# CITY OF ALBUQUERQUE

PLANNING DEPARTMENT – Development Review Services

**RE: Paseo Del Norte Sports Complex (File: C17D008)**  
**Drainage Management Plan, Engineer's Stamp Date 11-4-2014**  
**Supplemental Calculations received 10-30-14**

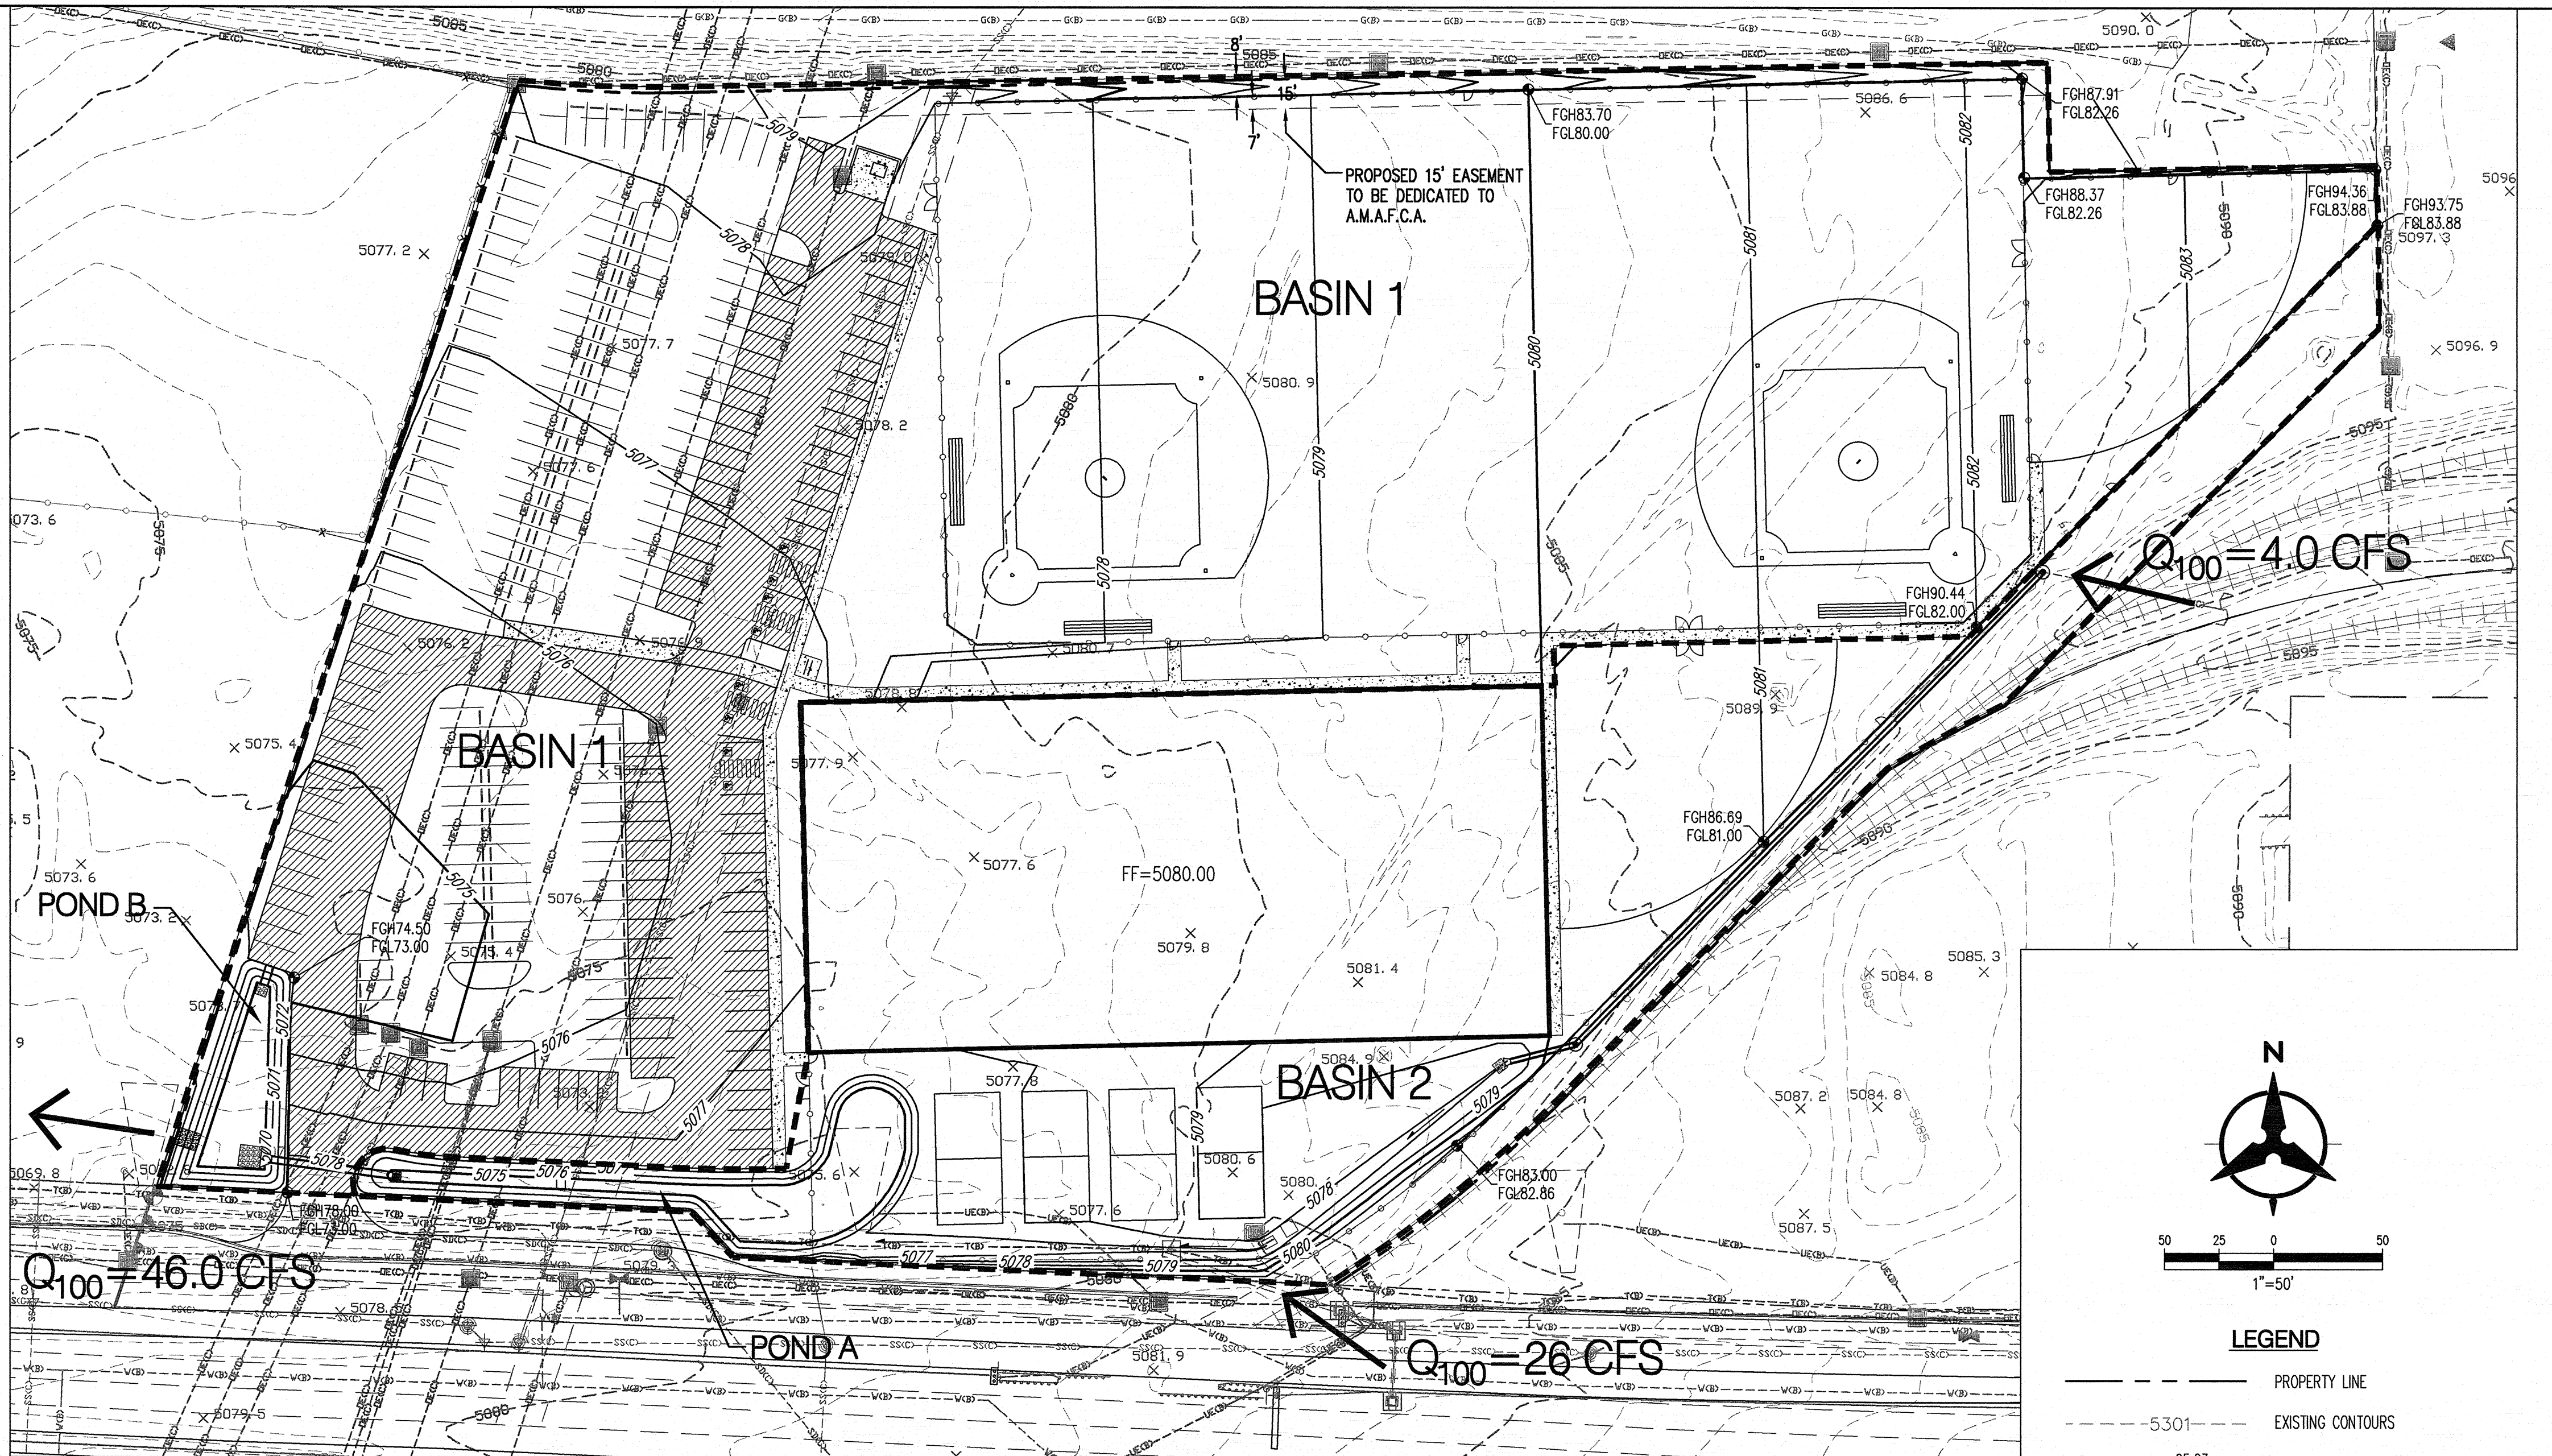
1. Show emergency overflow for Pond A.
2. Pond A needs to have 1' of freeboard
3. Detail rip-rap at Pond B (call out rock size and dimensions of rip-rap)
4. Show contours/spot elevations at waterblock
5. Flowline elevation along decel lane
